From: [Squire, Sandra](#)
To: [Heckington Fen Solar](#)
Subject: Heckington Fen Solar - ExQ1
Date: 01 November 2023 11:39:26

Re: BIO.1.3 – Woodlands

FIGURE 3.8 – Extent of Plantation clearance in Additional Works areas at Bicker Fen National Grid Substation

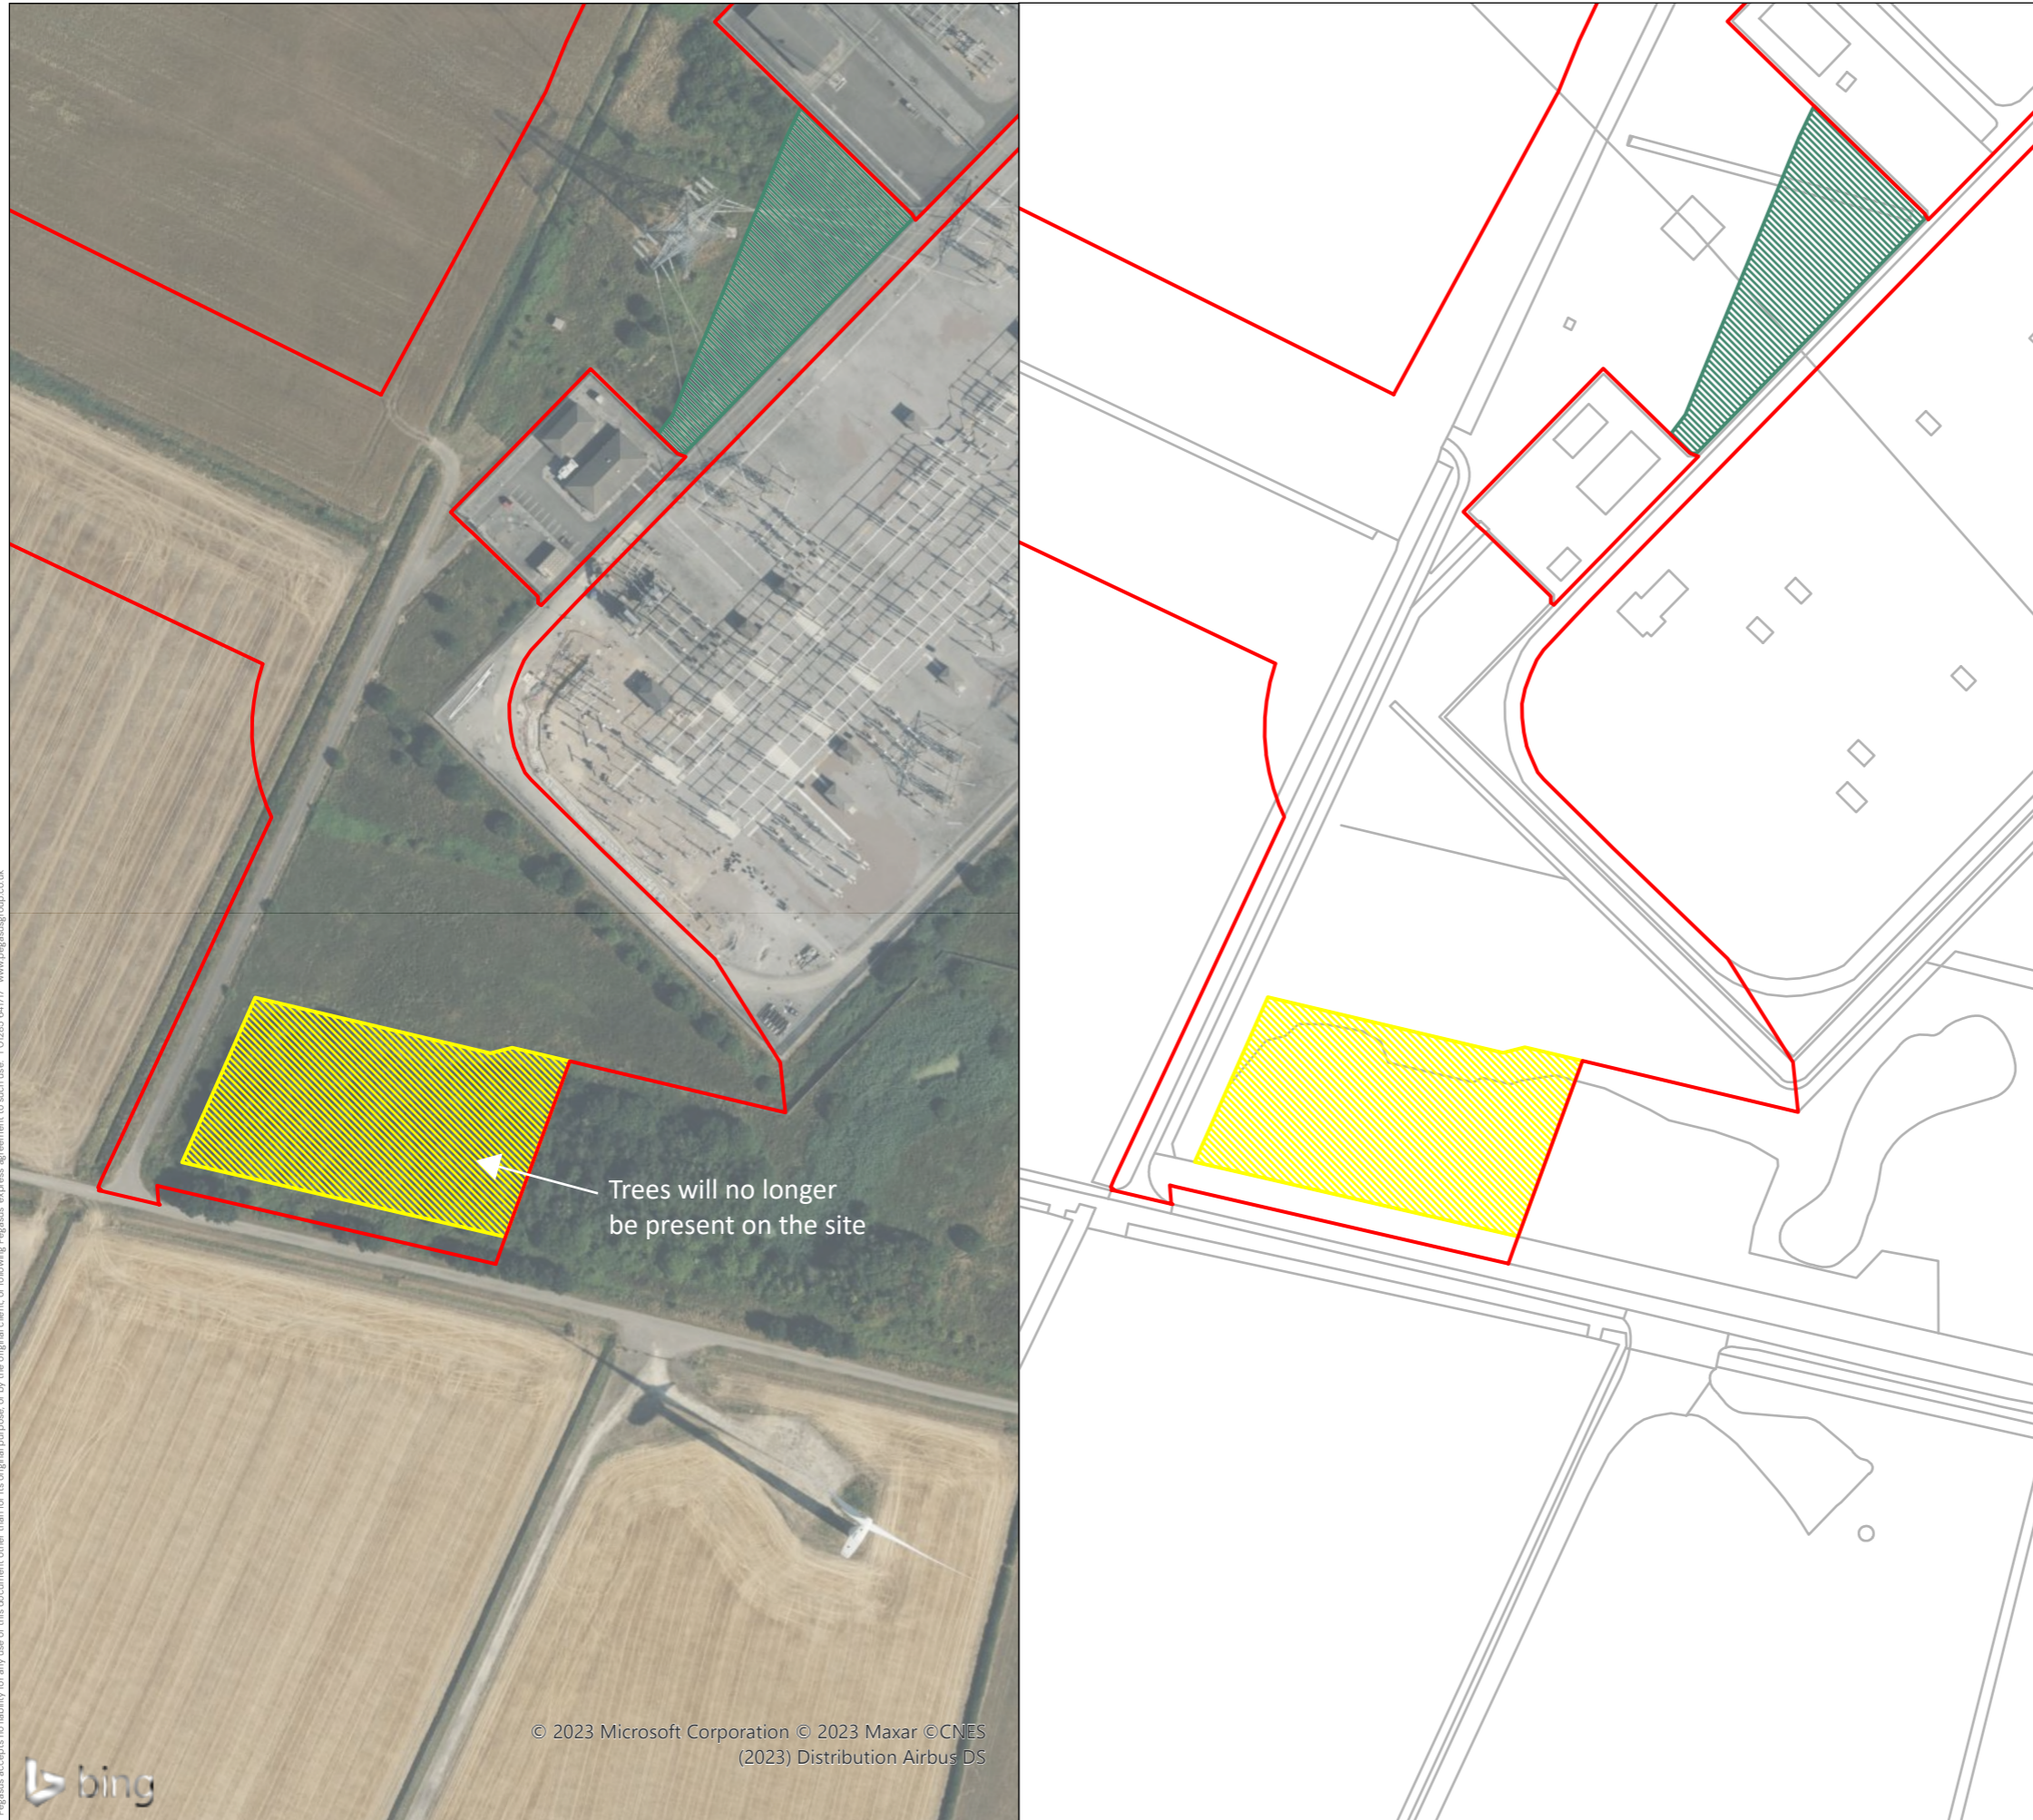
We note the applicants response regarding the removal of the woodland at the Bicker Fen Substation with the additional proposed compensatory woodland planting in the north of the site and within the hedgerows.

We are satisfied this will compensate for the loss of the woodland at Bicker Fen, however it may be beneficial if the new woodland was connected to the hedgerows around the site for better connectivity for wildlife.

Also, we would recommend that a woodland management plan is produced for the newly created woodland. A managed woodland can better withstand extreme weather events, be more resilient to the threat of pests and diseases and increase biodiversity. For example, controlling mammal populations and removing invasive plants can limit damage to young trees.
